V4_Storm Construction Plans.pdf Markup Summary

SHEET NUMBER
C6.5

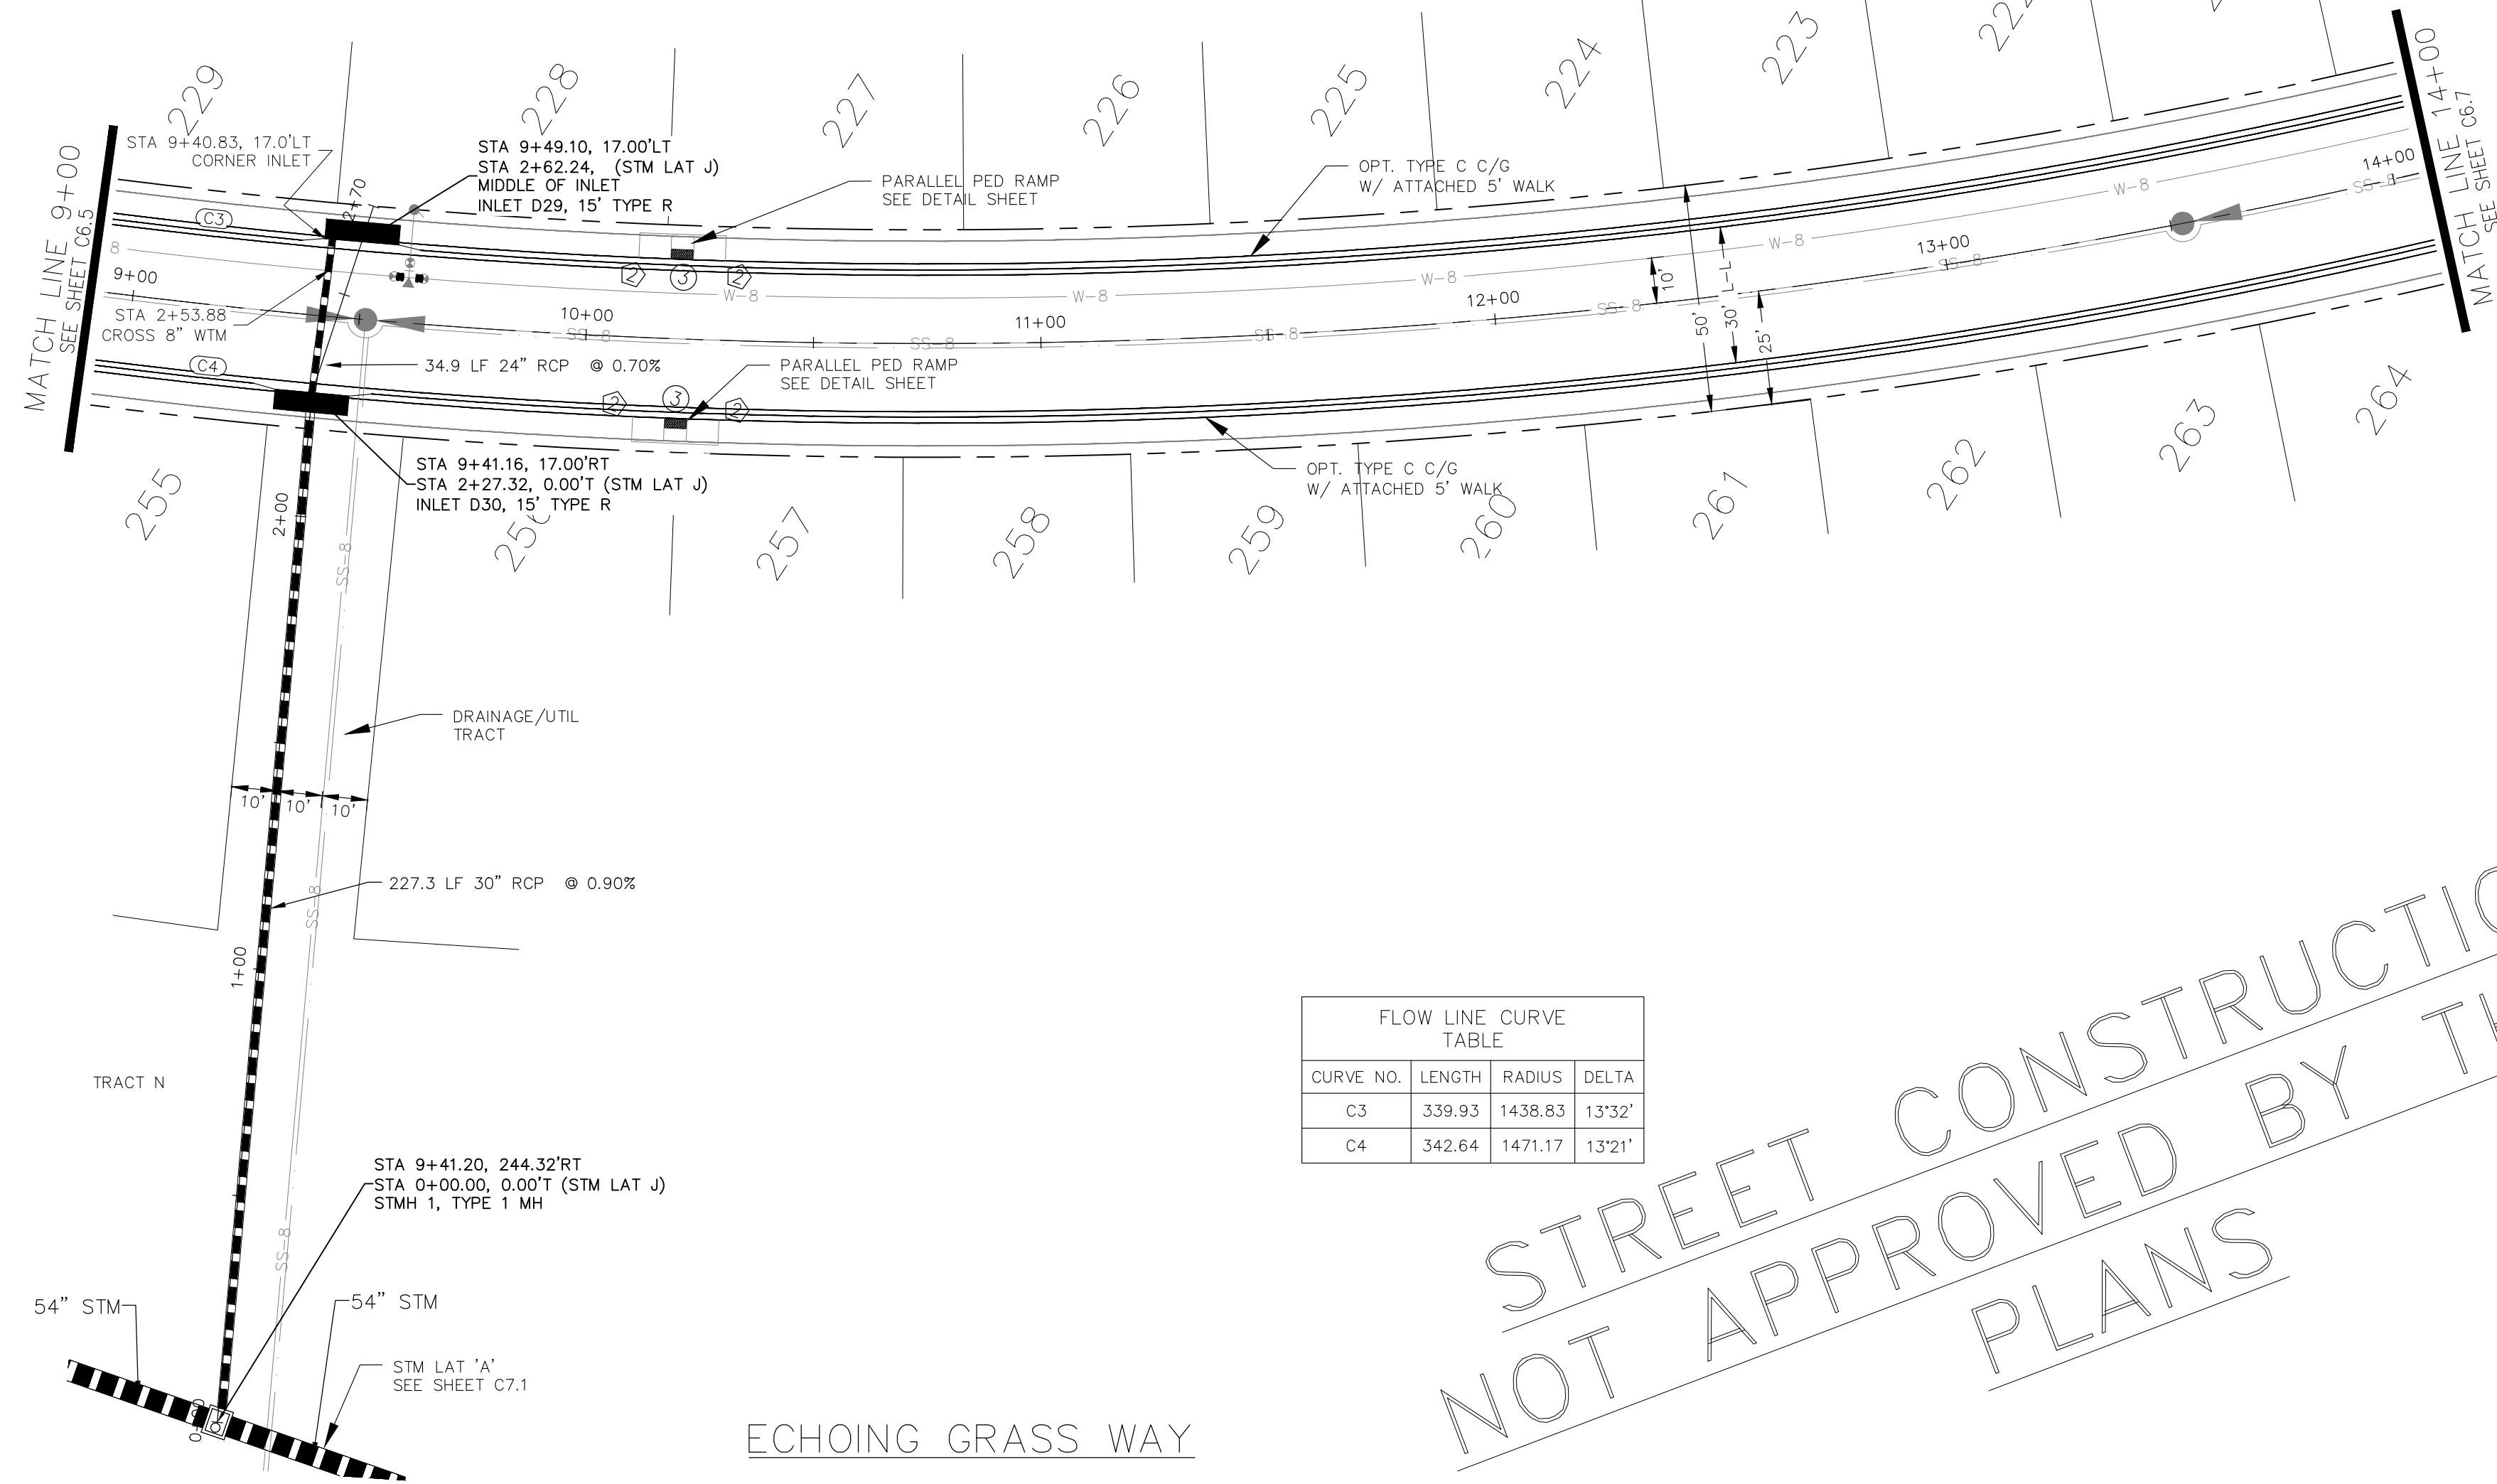
Show and label the easement

Stm. Lat. J is in Tract 'n'. Tract 'n' is a d/u tract and additional easement lines are not necessary. Tract 'n' is labeled on this sheet.

SHEET NUMBER
C7.1

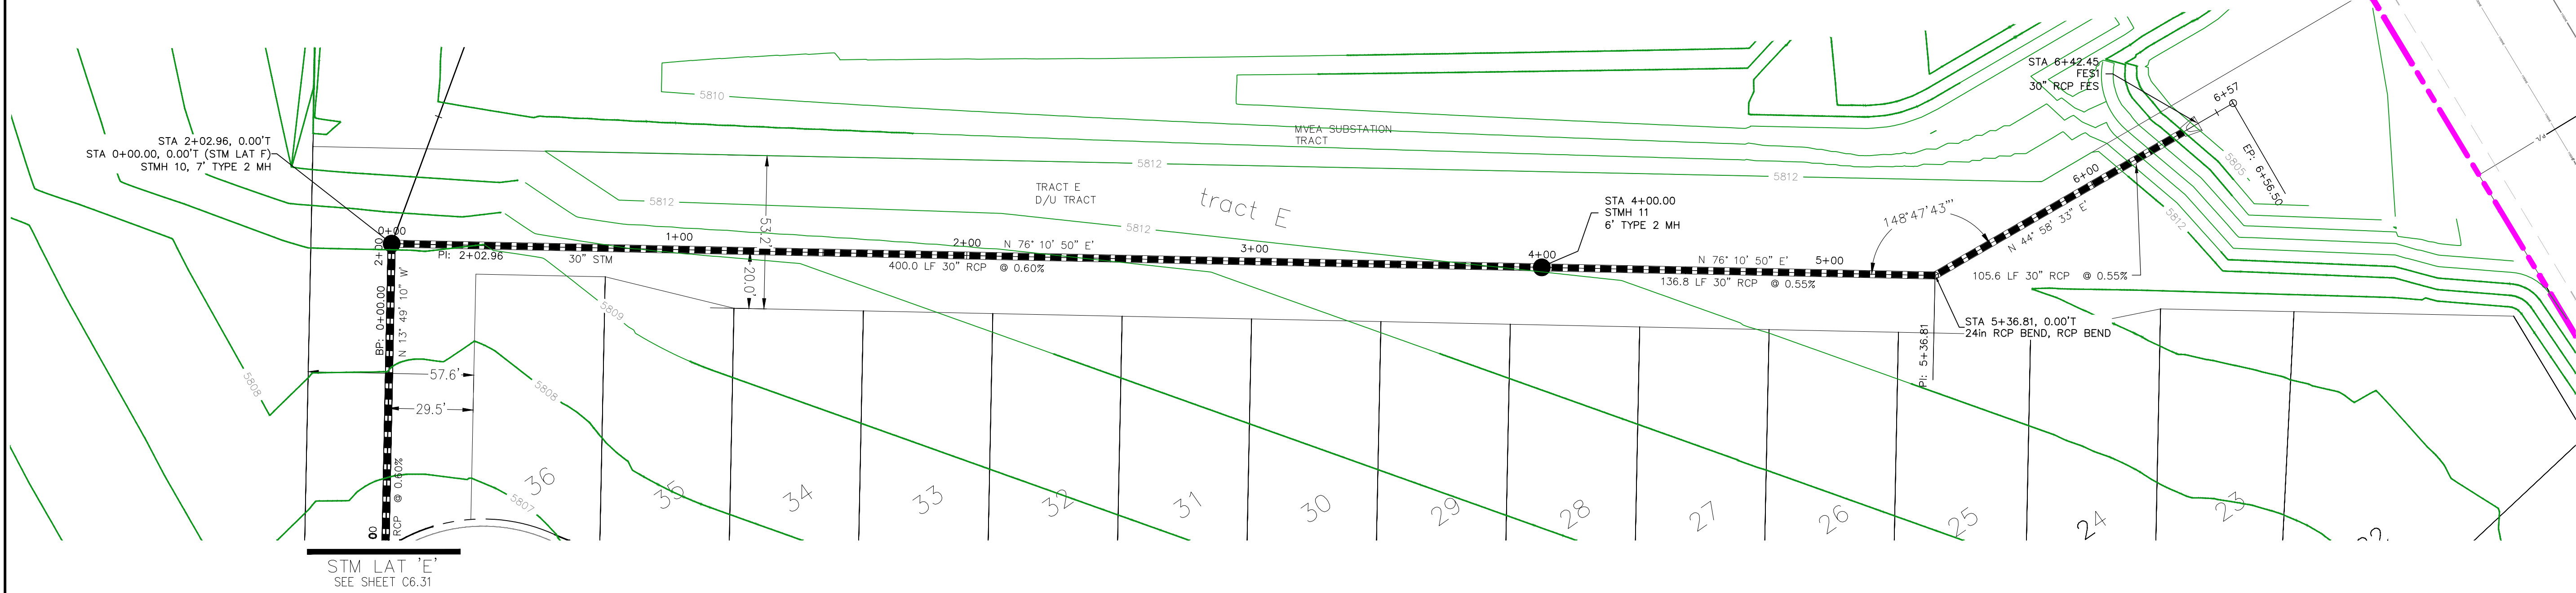
Show the storm sewer easement.

Stm. Lat. A is shown on sheet C7.3 which is in Tract 'n'. Tract 'n' is a d/u tract and additional easement lines are not necessary. Tract 'n' is labeled on this sheet.
